DECISION DELEGATED TO DEVELOPMENT MANAGER
--

Application No:	H13-1242-19	Applicant:	Kirk Homes Limited
Proposal:	Proposed extensions to dwelling		
Location:	The Old Coach House 107 High Road Moulton		
Terminal Date:	28th February 2020

Drawing Title:
Tree Plantation Plan as proposed.

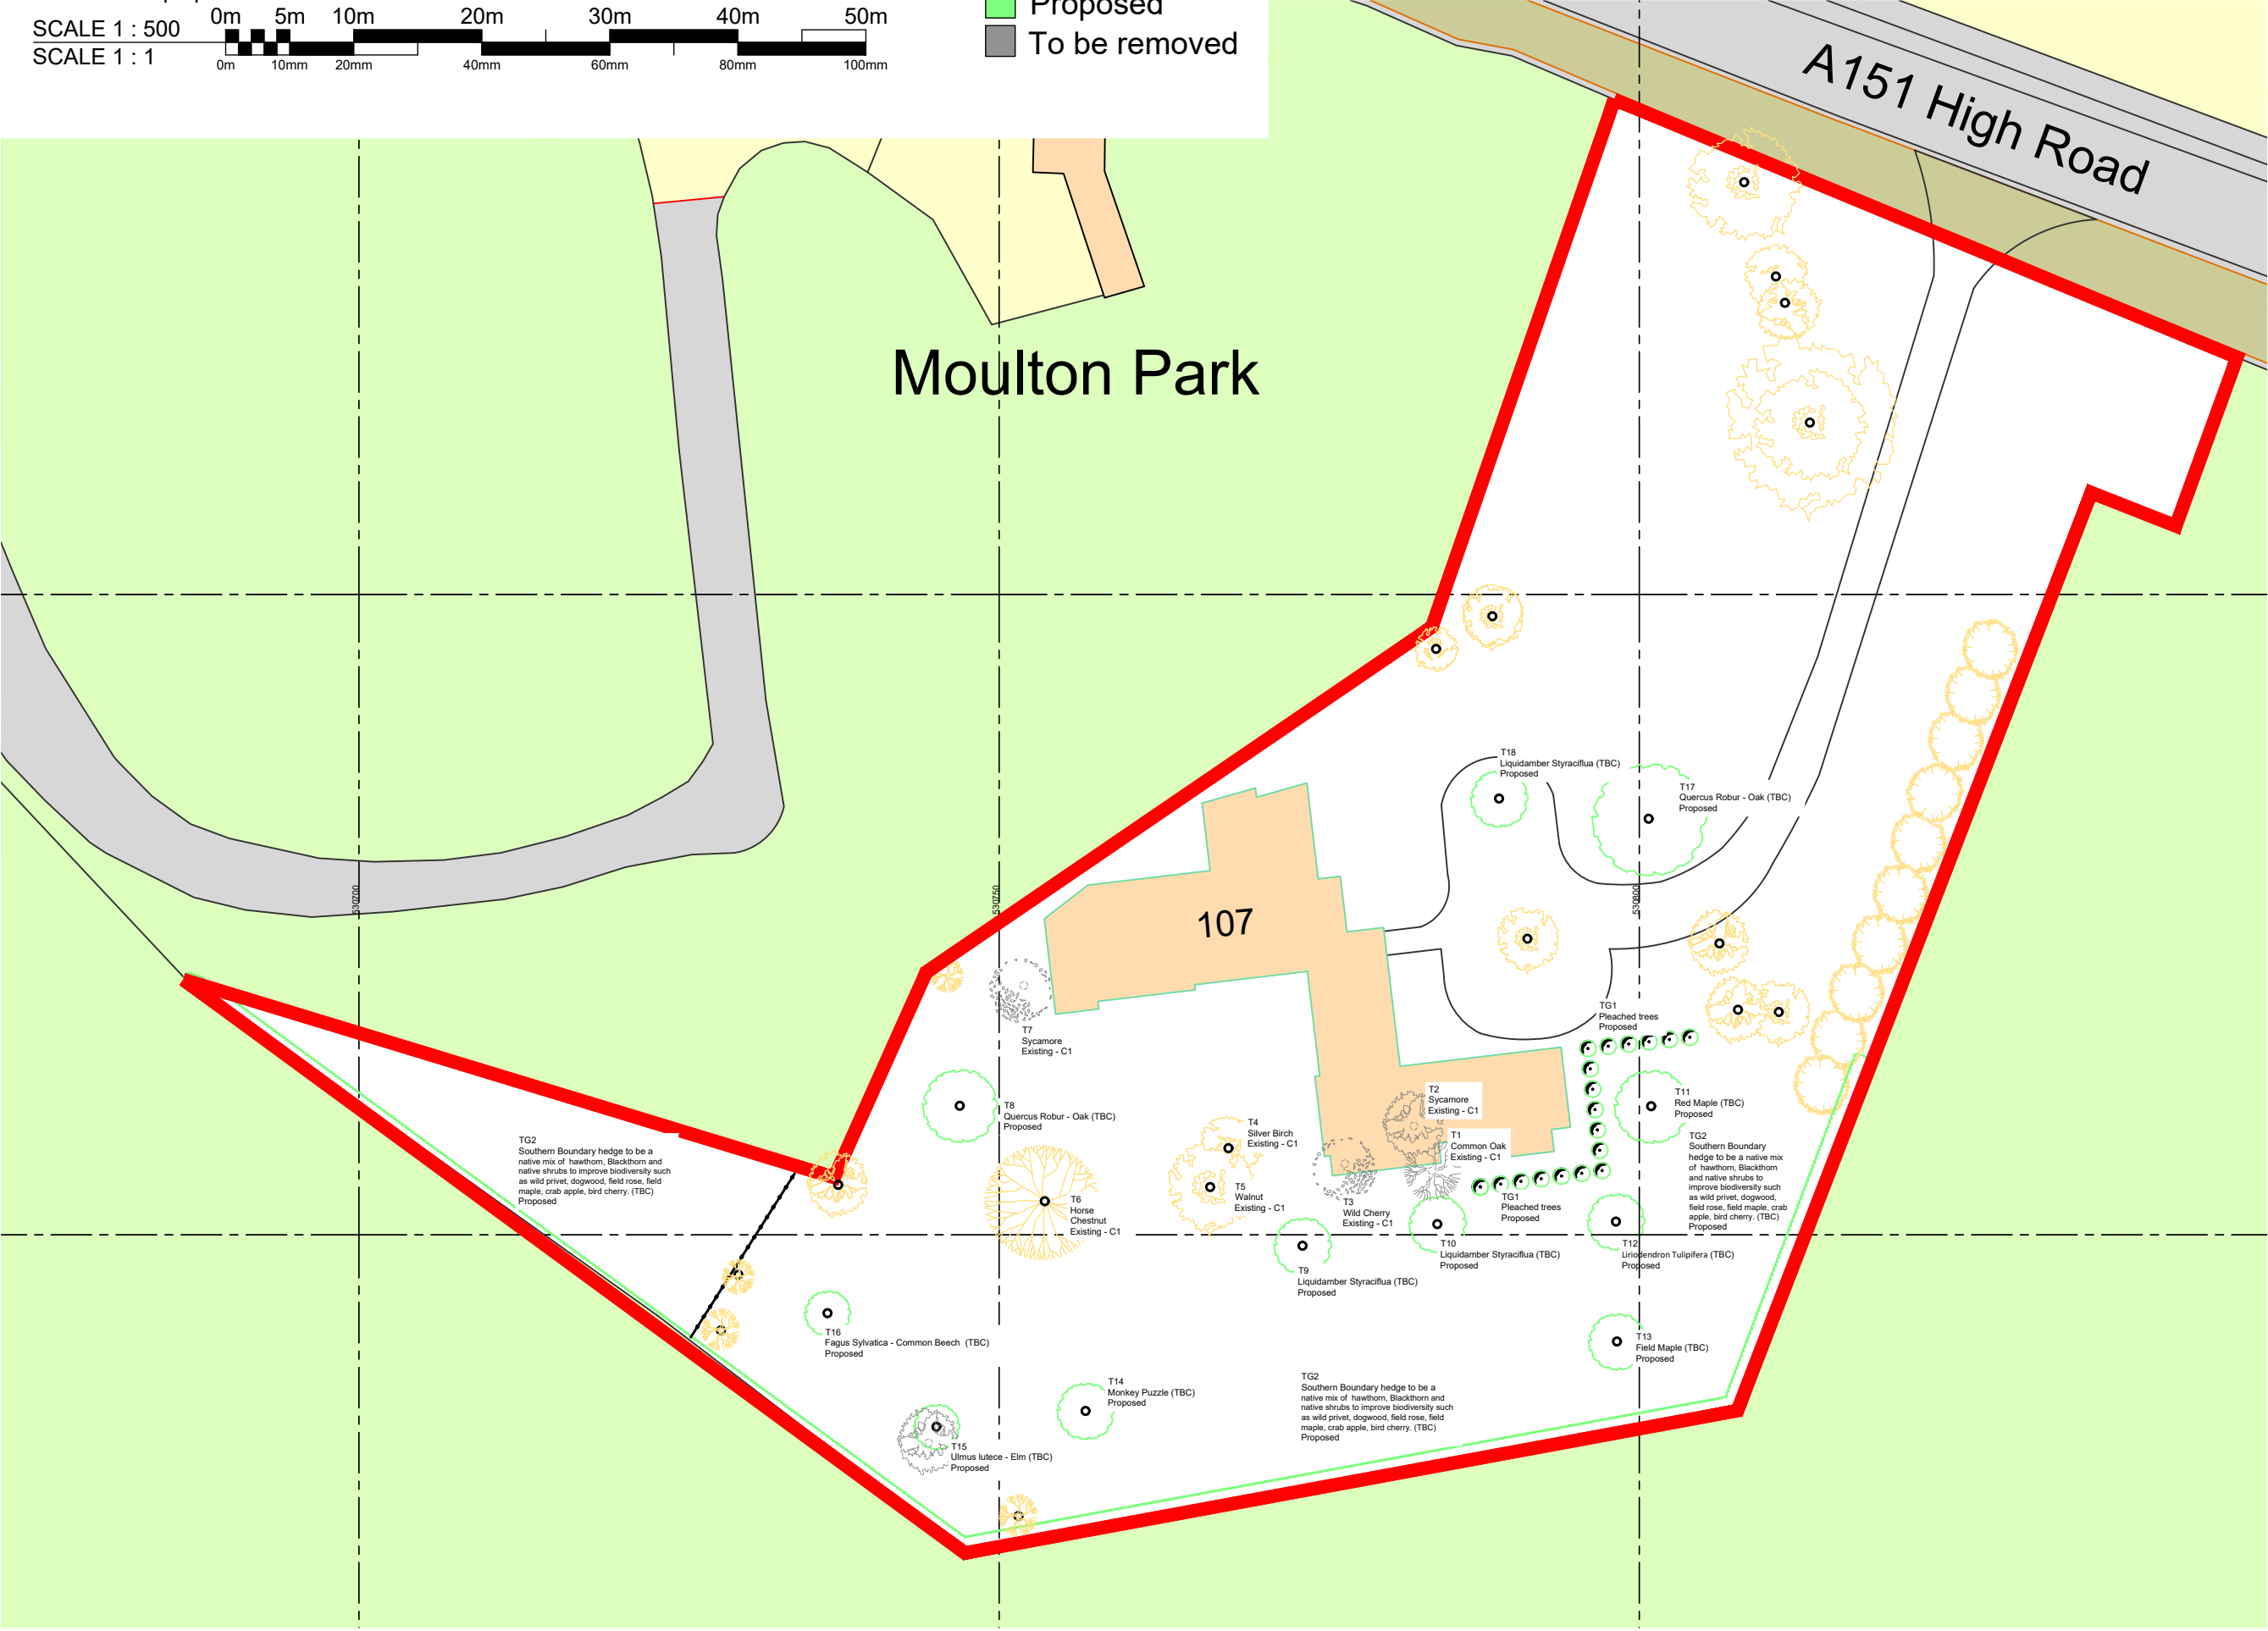
The amount and range of replacement trees proposed is encouraging. It may, however, be prudent to review the positioning of some of the proposed trees such as T8, *Quercus robur*, to be further from the dwelling whilst there is an opportunity. The positioning of the proposed *Liquidamber styraciflua* will be dependent on the specific variety chosen.

Replacement trees ought to be protected for a minimum period of 5 years from the date of planting by means of a condition.
